Subject: New comments for application 19/01746/OUT

New comments have been received for application 19/01746/OUT at site address: Land Adj To Promised Land Farm Wendlebury Road Chesterton

19/01746/OUT Land Adj To Promised Land Farm Wendlebury Road, Chesterton In my capacity as chair of the Bicester Bike Users Group (BicesterBUG), I am writing to raise my concerns regarding the inadequate provision of active travel network connectivity with regard to the above outline planning application.

Fig. 27 Proposed infrastructure plan, DTA drg no 19539—11—12 Wendlebury Road Site Access Roundabout

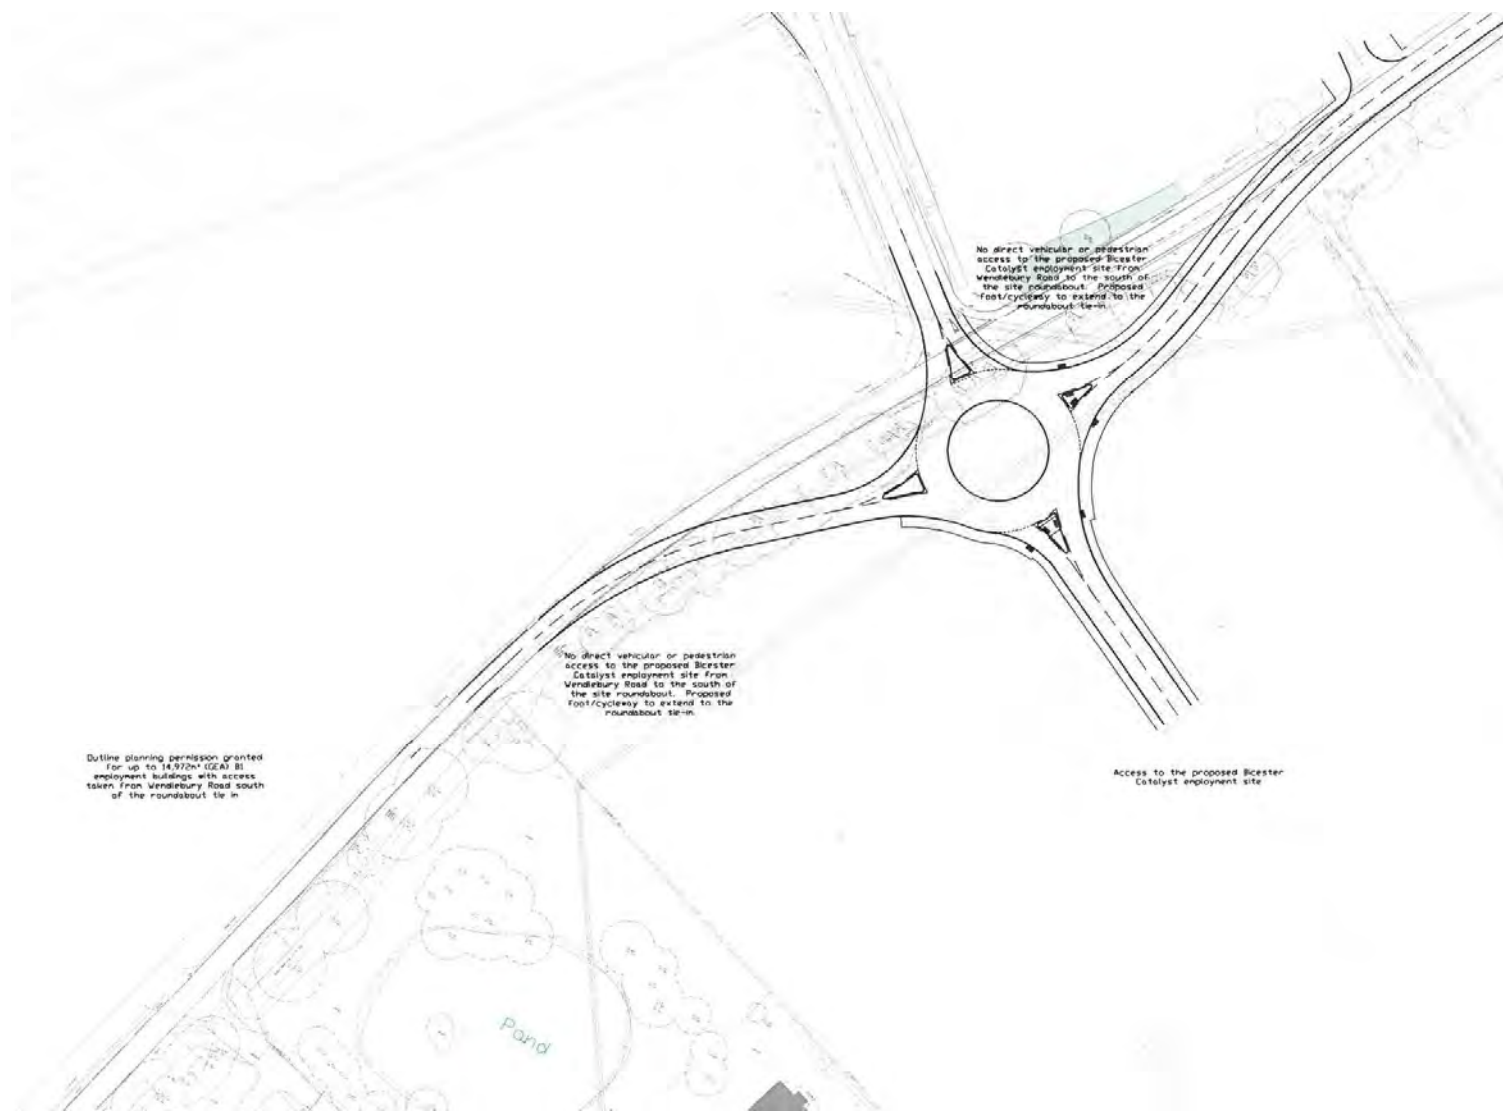
2) The development includes a significant section of NCN51 along Wendlebury road. The plans claim to improve the cycling provision but indicate only a mixed use path of 2.5 m width without cycle

priority at side junctions; therefore not in accordance with the Cycling Design Standards.(6) We believe this is a significant impediment to the current situation which would result in increased cycling times and discourage active travel along this section.

3) Given the additional car and HGV traffic (quoted as being 600-1800 cars per hour and 1000-3000HGVs per day) then a segregated cycle path with priority over the adjoining roads in a 'dutch style' roundabout should be considered. BicesterBUG rejects the claim that the traffic level is below a supposed 'intimidation threshold', new and unsure cyclists would be actively discouraged by the planned changes and increases in traffic from travelling in the area.
